WEST SUSSEX COUNTY COUNCIL CONSULTATION

TO:	Arun District Council FAO: Simon Davis
FROM:	WSCC - Highways Authority
DATE:	22 March 2021
LOCATION:	Land at Bilsham Road Yapton
SUBJECT:	Y/152/20/RES Approval of reserved matters (appearance, landscaping, layout and scale) following the grant of Y/91/17/OUT for 250 No. dwellings with associated parking, road/footway/ cycleway provision, open space, landscaping, surface water attenuation & ancillary works.
DATE OF SITE VISIT:	n/a
RECOMMENDATION:	More Information
S106 CONTRIBUTION TOTAL:	n/a

West Sussex County Council (WSCC) have been consulted upon planning application Y/152/20/RES by Arun District Council (ADC). This application seeks Reserved Matters approval for the erection of 250 dwellings associated with the Yapton Strategic Site SD7 and outline planning consent Y/91/17/OUT.

CLIENT: Bisham Road Development LLP		PROJECT: Land At Bisham Road, Yapton	
SCALE: 1:500 (A0 ORIGINAL)		DRAWING: Surface Material Layout Sheet Two	
DRAWN: RB/SA DATE: Sep 2020	19284	P105.2	—

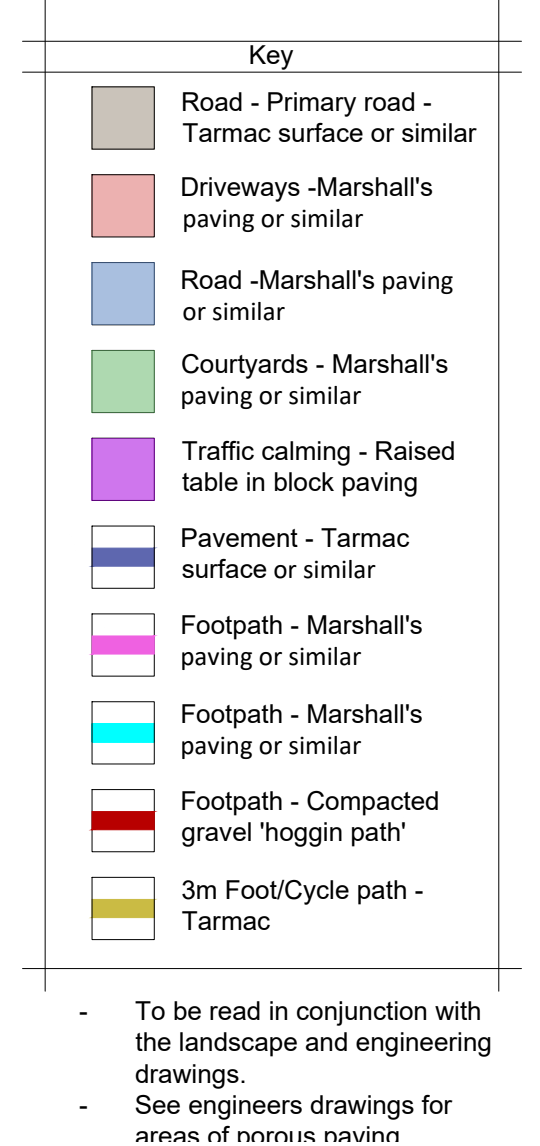
- **Footway outside plots 36 – 41** – outside these plots to the site access on Bilsham Lane there are several short sections of pavement leading to the spine road (Surface Material Layout Sheet Two drawing number 19284 P105.2). It is not apparent as to the rationale for the number of sections of footway in this location and whether they are located in the best places (ie very close to the site access where a dropped kerb/tactile paving crossing is proposed & in align with the ramped section of the raised table traffic calming features). The applicant should provide clarification as to the rationale and the wider issue of where they intend to provide crossing facilities and in what form across the site's spine road.
